6420 CENTRAL AVE S.W.
ALBUQUERQUE, NEW MEXICO

SITE PLAN, DESIGN DATA
AND NOTES

Re: Sonic Drive-in – 6420 Central Ave. NW Albuquerque
Request for Certificate of Occupancy
Transportation Development Final Inspection
Engineer's/Architect's Stamp dated 06-02-17 (K11D047)
Certification dated 11-09-2018

SHEET TITLE
SITE PLAN, DESIGN DATA AND NOTES

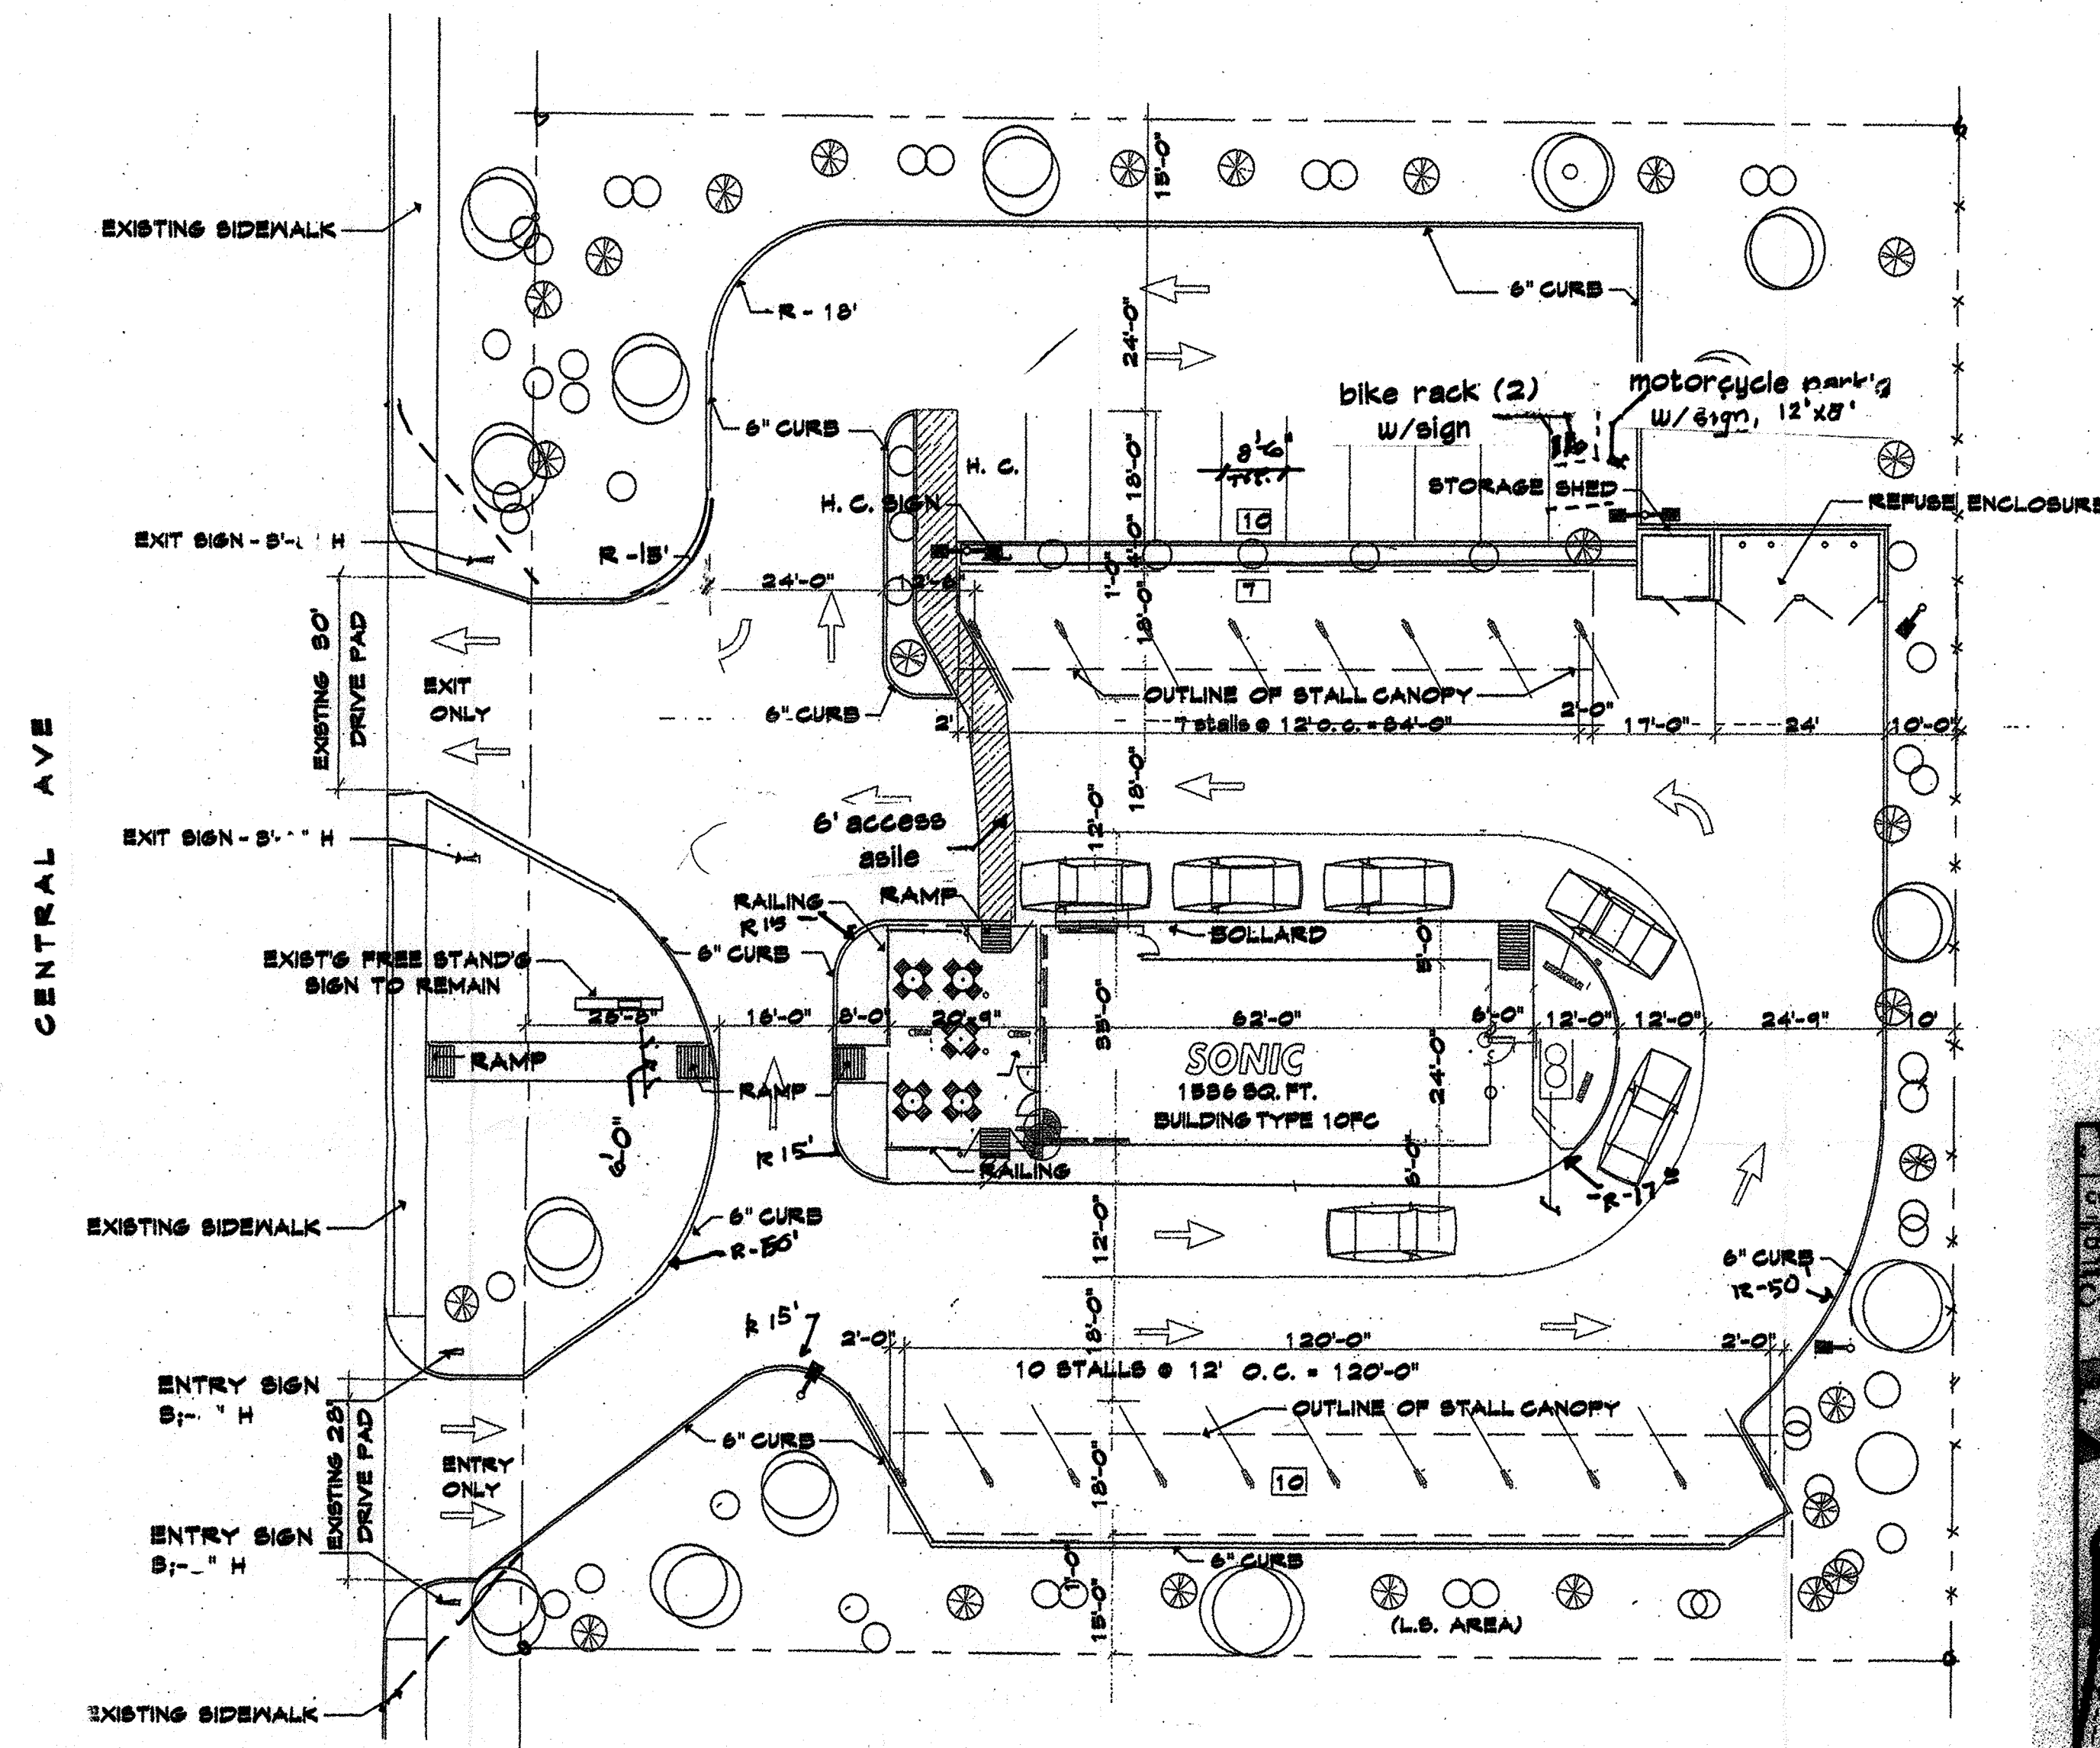
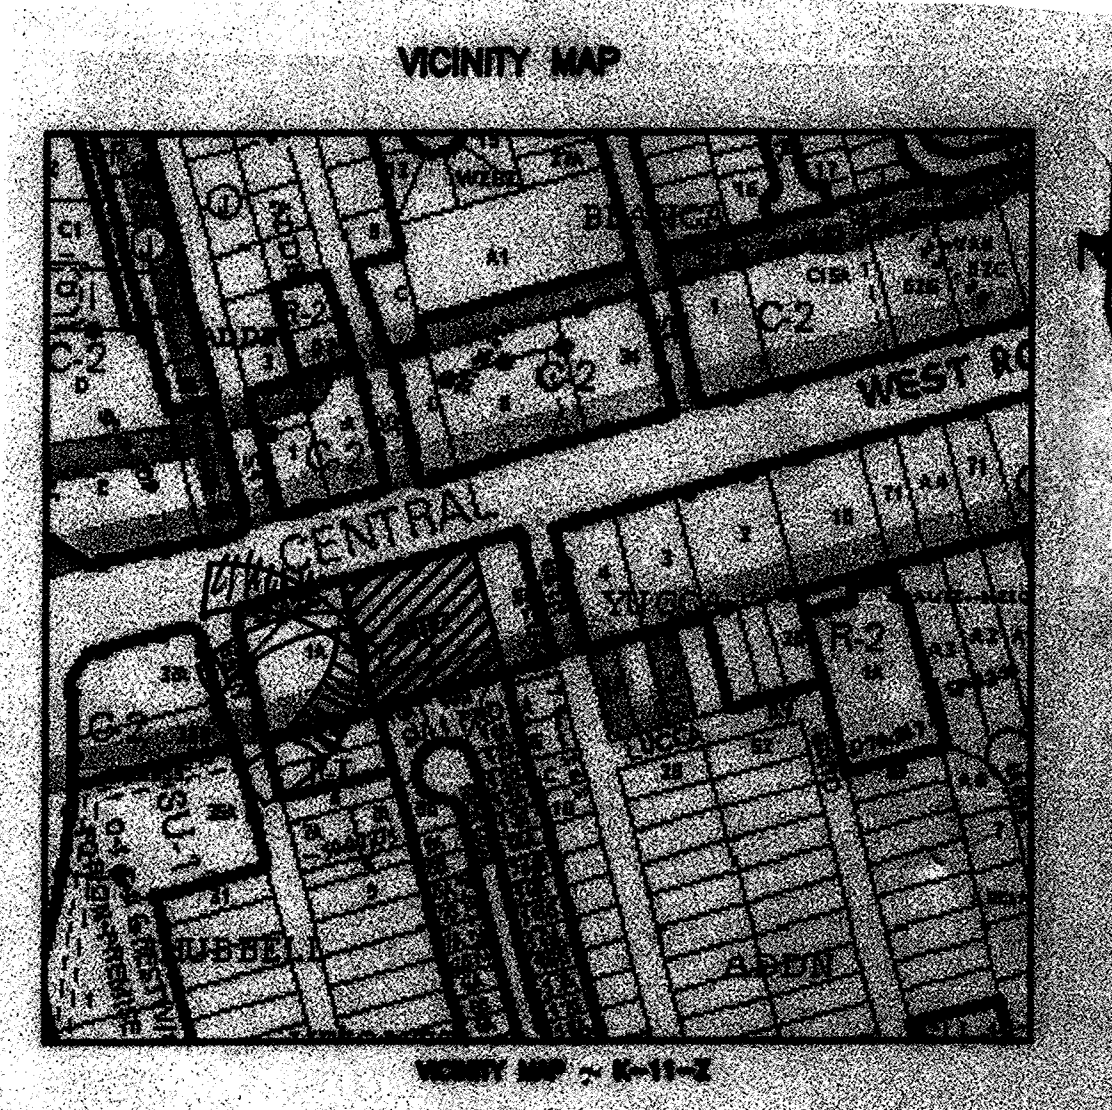
The ADA accessible parking sign must have the required language per 66-7-352.4C NMSA 1978 "Violators Are Subject to a Fine and/or Towing." Please call out detail and location of HC signs.

The ADA access aisles shall have the words "NO PARKING" in capital letters, each of which shall be at least one foot high and at least two inches wide, placed at the rear of the parking space so as to be close to where an adjacent vehicle's rear tire would be placed. (66-1-4.1.B NMSA 1978)

Motorcycle parking spaces shall be designated by its own conspicuously posted upright sign, either free-standing or wall mounted per the zoning code.

Per the zoning code, a 6 ft. wide ADA accessible pedestrian pathway is required from the public sidewalk to the building entrances. Please clearly show this pathway and provide details.
